July 13, 2023

Re: 9909 Indian School
9906 Indian School Rd. NE
Traffic Circulation Layout
Engineer's/Architect's Stamp XX-XX-XX (J20-D041)

Please find below responses to the comments provided for my initial submittal:

AS101

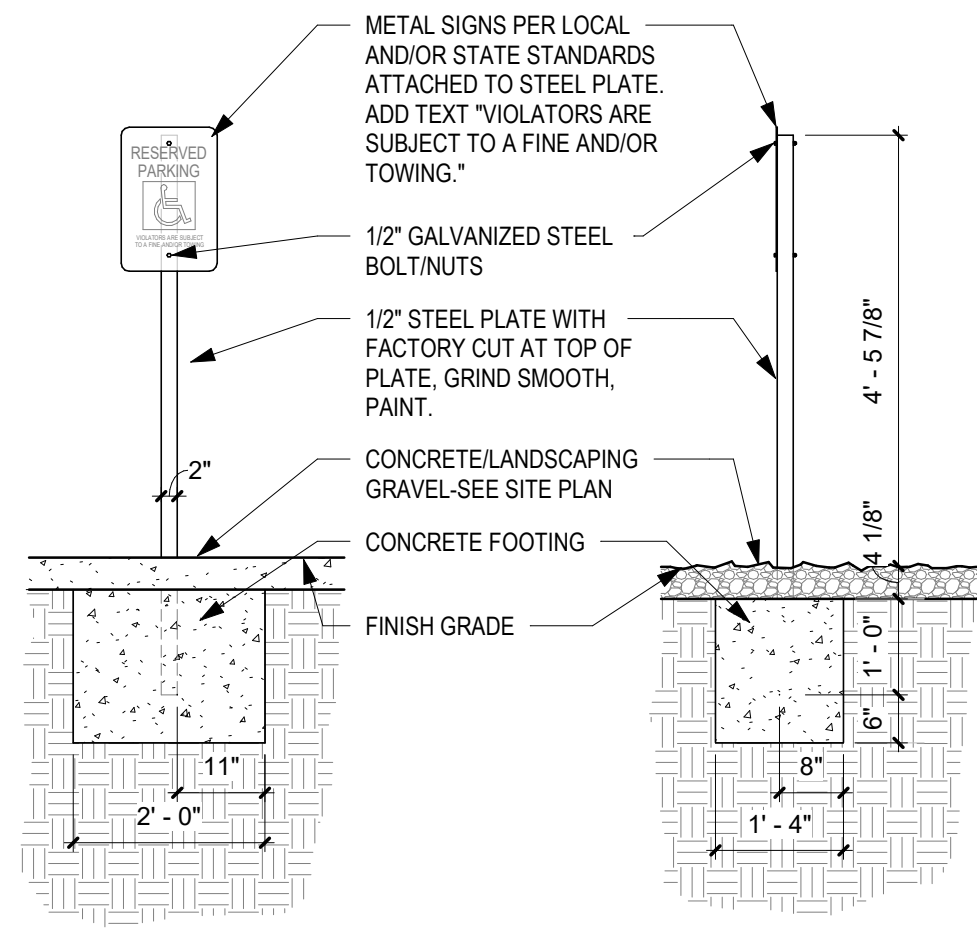
1. Please show a vicinity map showing the location of the development in relation to streets and well-known landmarks.
 - a. Please see AS101 showing a vicinity map.

2. List the number of Motorcycle and Bicycle parking spaces required by the IDO.
 - a. Please see AS101 for motorcycle and bicycle spaces as required per the IDO.

3. Identify all existing access easements and rights of way width dimensions.
 - a. Please see demo plan with right of way widths and site plan for easements

4. Identify the right of way width, medians, curb cuts, and street widths on Indian School Rd.
 - a. Please see demo and new site plan
5. Please provide site access's design details, and reference COA std dwg.

- a. Please see new site plan for site access design and reference to CoA std dwg(s)
6. Please list the width and length for all existing and proposed parking spaces. Some dimensions are not shown.

- a. Spaces have been dimensioned
7. The minimum parking stall dimensions.
 - a. Stalls have been updated
8. The ADA accessible spaces must include an access aisle. Van accessible aisles should be 8ft wide; all others should be 5ft wide.

- a. Aisle has been updated
11. ADA curb ramp at the corner of Indian School and the Public Alley must be updated to current standards and have truncated domes installed.

- a. See included fire marshal approval
13. Motorcycle parking spaces shall be designated by its own conspicuously posted upright sign, either free-standing or wall mounted per the zoning code.

- a. Space and sign have been added to the plan
14. The pavement marking "MC" should be shown in the opposite direction for motorcycles entering the parking space.

- a. Pavement marking has been added to the plan
15. All bicycle racks shall be designed according to the following guidelines:
 - a. Bicycle rack added to the plan per the guidelines

16. Bicycle racks shall be sturdy and anchored to a concrete pad.
 - a. Bike racks added to plan to meet guidelines
17. A 1-foot clear zone around the bicycle parking stall shall be provided.

- a. Clear zone provided
18. Bicycle parking spaces shall be at least 6 feet long and 2 feet wide.
 - a. Space sizes to meet requirements
19. The minimum drive aisle width for two-way traffic is 22 ft.

- a. Drive isle meets min width for two way
20. Show the Intersection clear sight triangle and add the following note to the plan:
"Landscaping and signage will not interfere with clear sight requirements. Therefore, signs, walls, trees, and shrubbery between 3 and 8 feet tall (as measured from the gutter pan) will not be acceptable in the clear sight triangle."

- a. Clear site indicated on plan
21. Please specify the City Standard Drawing Number when applicable.
 - a. CoA std dwgs indicated where applicable
22. Unused curb cuts must be replaced with sidewalk and curb & gutter. A build note must be provided referring to the appropriate City Standard drawing.

- a. ADA van space has been adjusted with 8ft wide aisle
9. The ADA accessible parking sign must have the required language per 66-7-352.4C NMSA 1978 "Violators Are Subject to a Fine and/or Towing." Please call out detail and location of signs.

- a. Curb ramp has been indicated to be updated, see site plan
12. Provide a copy of Solid Waste and Fire Marshal approval.
 - a. See included solid waste approval

- a. Note added to plan
